Householder Application for Planning Permission for works or extension to a dwelling.
Town and Country Planning Act 1990

Proposed 4.5m sliding doors to rear barn facade, to create an open plan kitchen/dining.

Jane Ratcliffe
Project
Meadowside Barn, Whalley Road,
Wilpshire, BB1 9LN
Drawing No. P01
Revision C
Scale 1:100 @ A2
Date July 17'

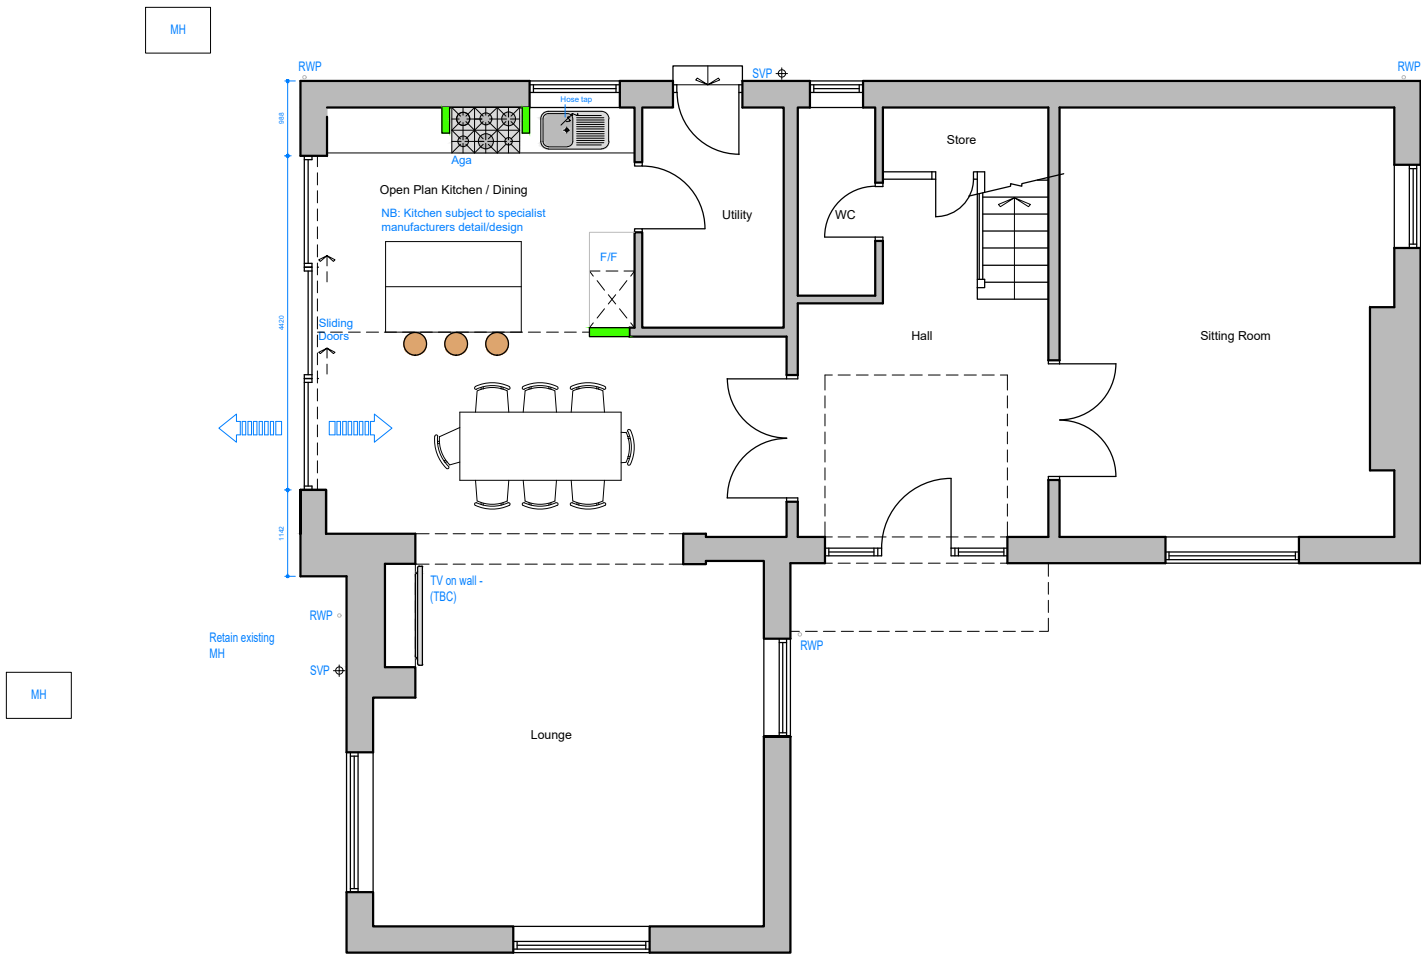
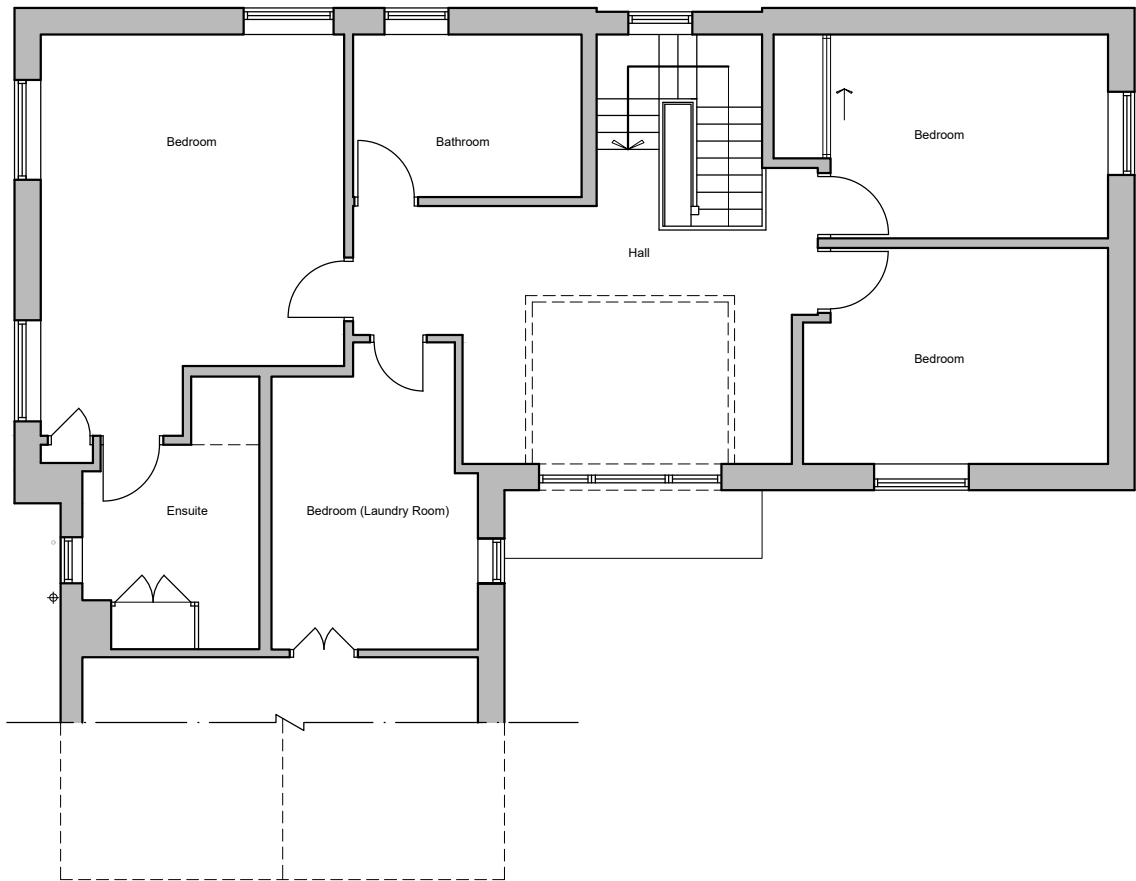
Upon reviewing the original conversion scheme it is clear that the two ground floor windows to the gable elevation of the barn were new additions. The suggested alteration to the opening would still maintain the inherent plan form of the building which as previously expressed should be retained to ensure that its character as a former barn is not lost.

On balance, and given the extent of the original conversion works I consider that the alteration to the opening as proposed on drawing P01 Rev. A to be acceptable and would therefore invite an application on this basis. I would advise that the frames are timber however to ensure that materials are sympathetic.
